# Comments for Planning Application 22/2198/CON

Application Number: 22/2198/CON

Address: 4 Nesbitts Alley Barnet EN5 5XG

Proposal: Submission of details of condition 5 (Refuse and recycling store) 6 (Cycle parking) pursuant to planning permission 21/1453/FUL dated 14/03/22

CONDITION 5 AND 6
21/1453/FUL

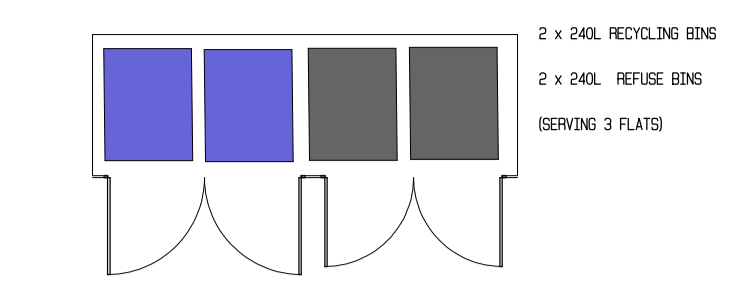
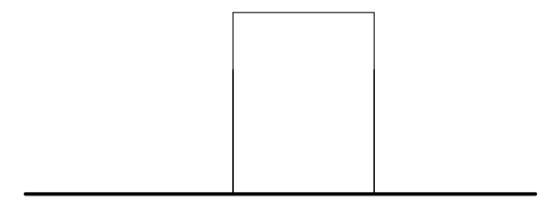
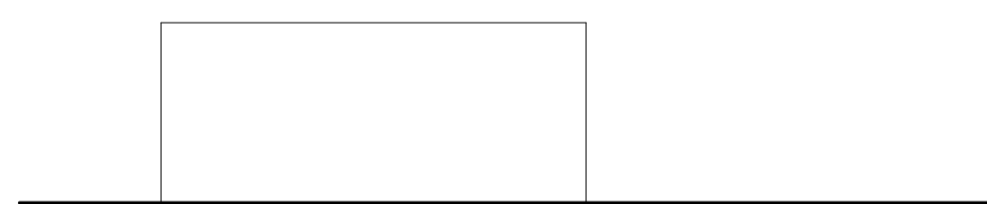
The drawing labels 4 Nesbitts Alley incorrectly as 6a Nesbitts Alley.

PLAN VIEW (1.50)

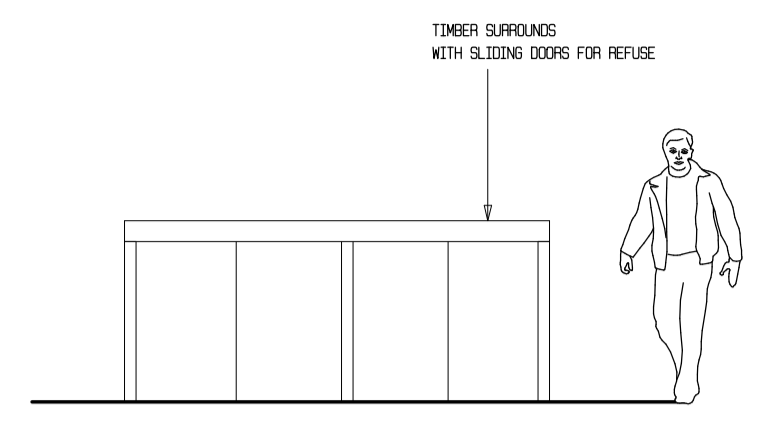
Comment: The drawings lack detail of the boundary between 6/6a Nesbitts Alley and 4 Nesbitts Alley. If no wall is proposed, the bins and the bike rack will be placed right in the middle of the courtyard.

The allocation of the bins and bike rack will limit the car parking spacing (2 required). As a neighbour I am concerned on-going tenants will continually block my access to No. 6a Nesbitts Alley.

The bin and bike rack are centrally located in the courtyard and will significantly block light to the lower ground unit of No. 6 Nesbitts Alley. Daylight study is requested to confirm that there will be no loss of light to that unit.
